25 June 2021

LW 424 – 427 Extraction Plan Groundwater Trigger Investigation

Attachment 1 - Response to DPIE Request for Information

Figure 4.1: SPR1301 Hydrograph - 7 day moving average

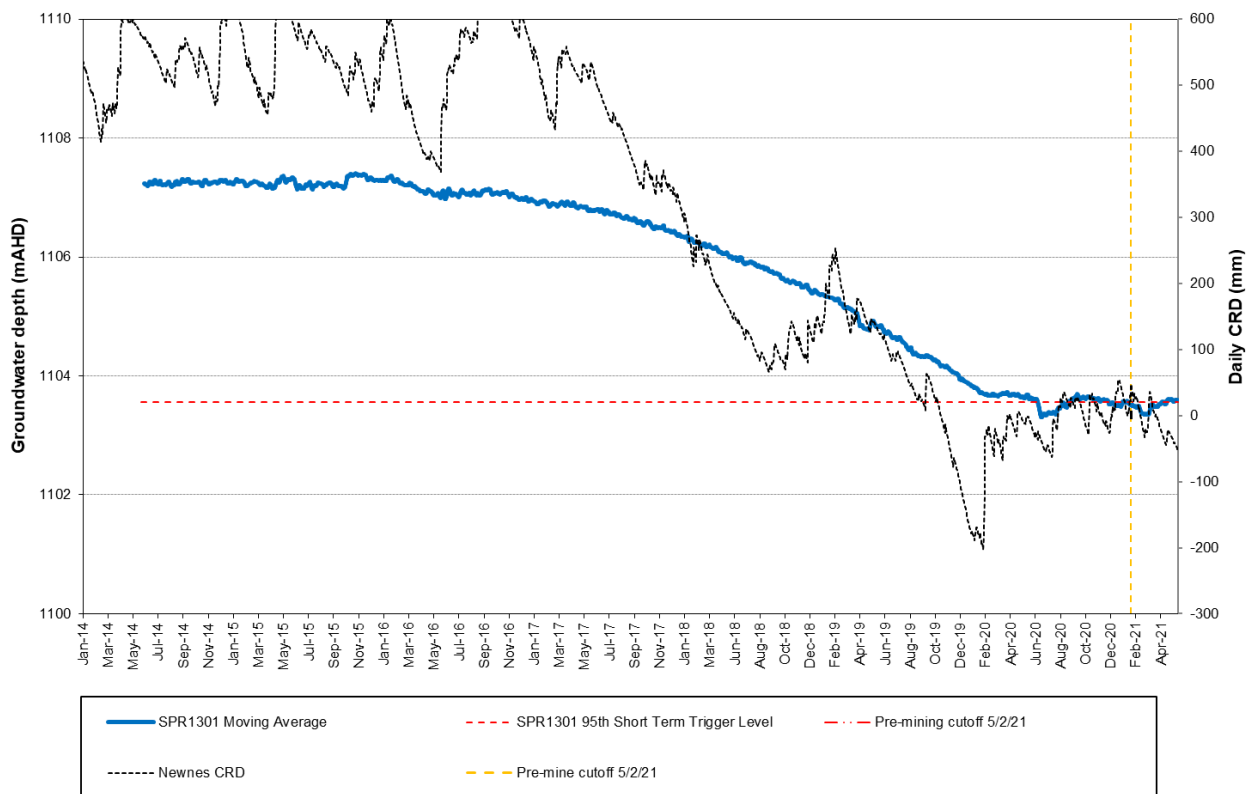
Request: *Confirm whether the hydrograph for SPR1301 is using a 7-day moving average – if not, please provide an updated hydrograph;*

Response: Figure 4.1 in the enclosed investigation report presents the 7 day moving average.

Request: *Confirm what groundwater level the red dashed horizontal line in the hydrograph represents (i.e. the short-term change trigger).*

Response: Figure 2 in the Notification Report provided 13 May and Figure 4.1 in the enclosed investigation report present the 95th percentile trigger value.

Figure 5.1: AP5PR Hydrograph comparison

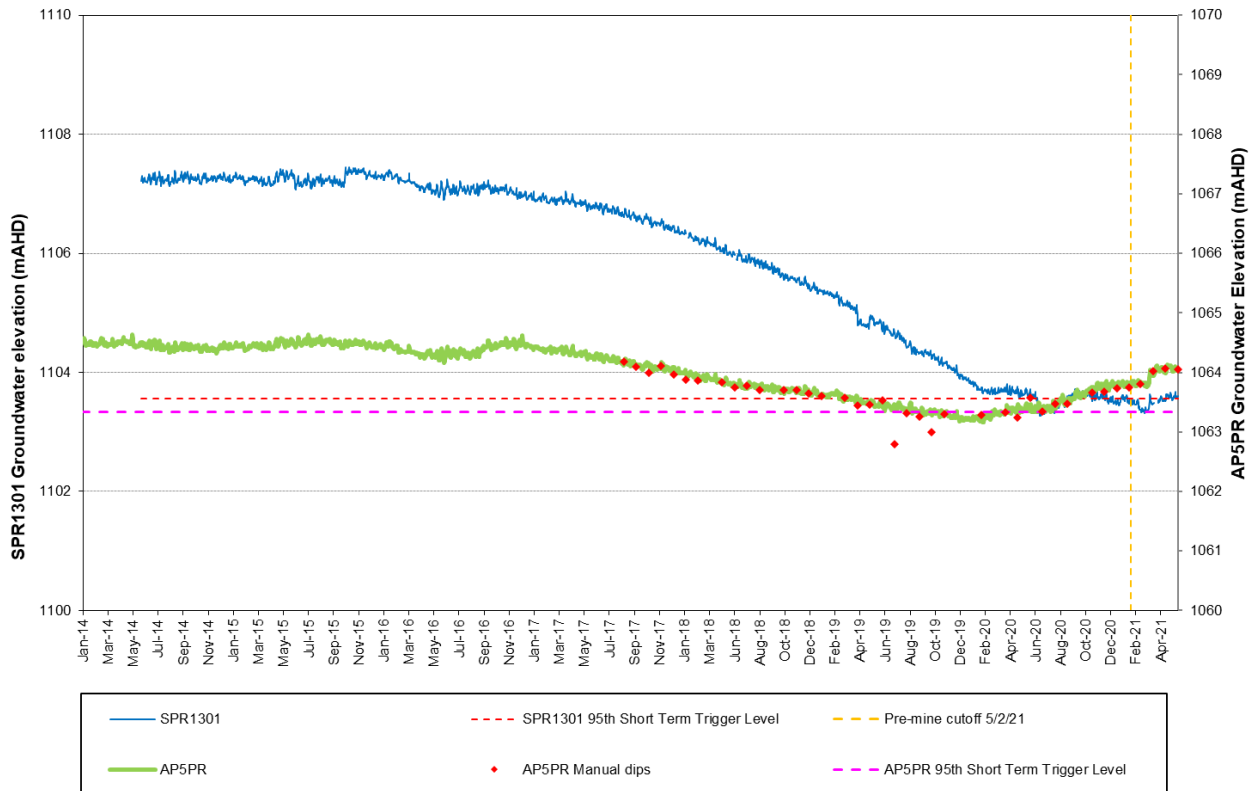
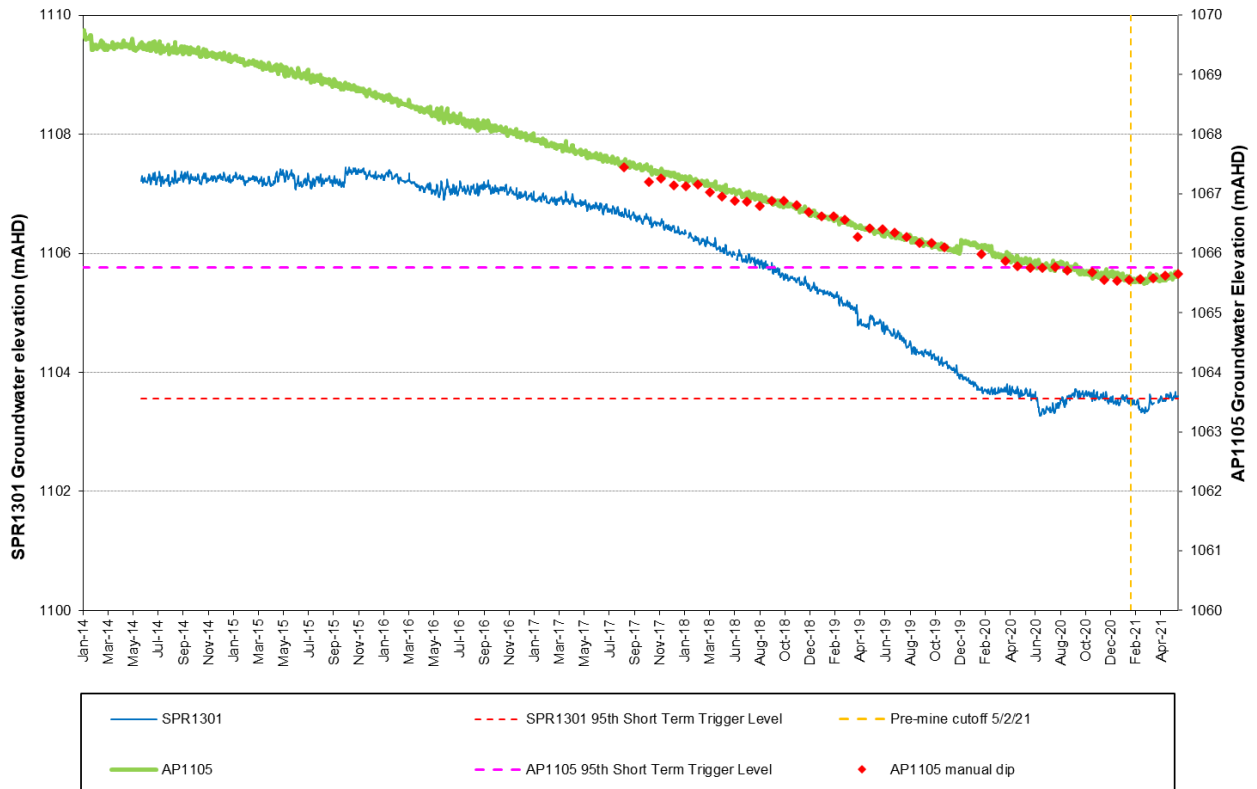
Request: A statistical comparison of the groundwater data at SPR1301 and other comparable reference sites (with a justification for the use of each proposed reference site). The report should also investigate whether any other adjacent groundwater level monitors are showing similar groundwater declines.

Response: A statistical comparison of the SPR1301 to reference sites is presented in Section 5.2 of the enclosed report. AP5PR and AP1105 are nominated reference sites within both the 424-427 Swamp Monitoring Program and Water Management Plan.

The AP5PR and AP1105 reference sites are located above the Angus Place Mine Extension Project Area which is well outside the influence of mining activities being undertaken by Springvale Coal. Both sites target the Banks wall of Sandstone where SPR1301 is screened.

Both AP5PR and AP1105 displayed declining trends during the drought and both fell below their comparative 95th percentile trigger. It is therefore concluded that similar groundwater trends have been observed at reference sites.

Figure 5.3: Marrangaroo Swamp Hydrograph

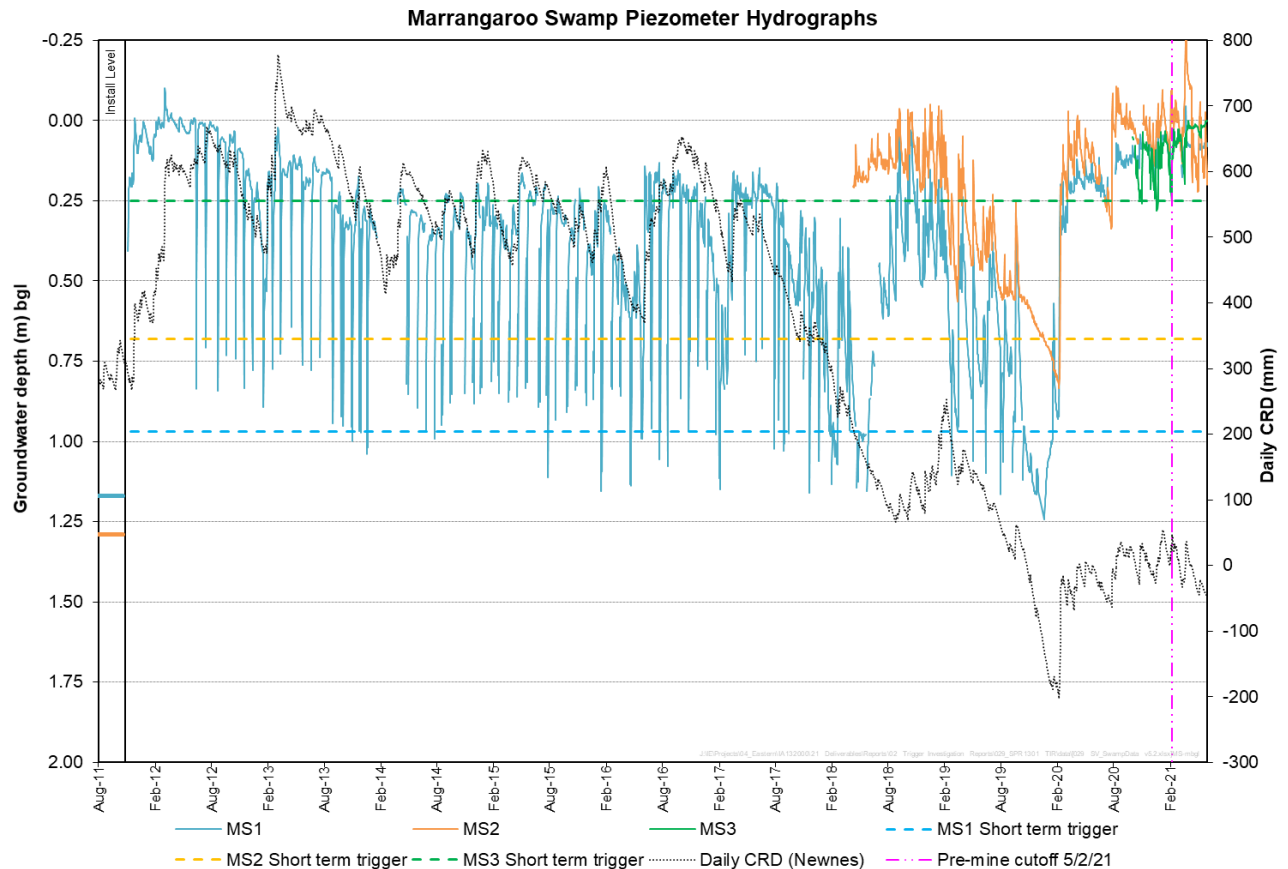
Request: An assessment of nearby swamp health indicators (particularly at Marrangaroo Creek Swamp), including swamp water levels and the state of vegetation.

Response: Marrangaroo Creek Swamp groundwater levels are presented in Section 5.7.1 of the enclosed report. The groundwater levels at Marrangaroo Swamp are above the 95th percentile short term trigger values and there are no observable negative mining impacts. Groundwater levels are in line with the prevailing rainfall conditions.
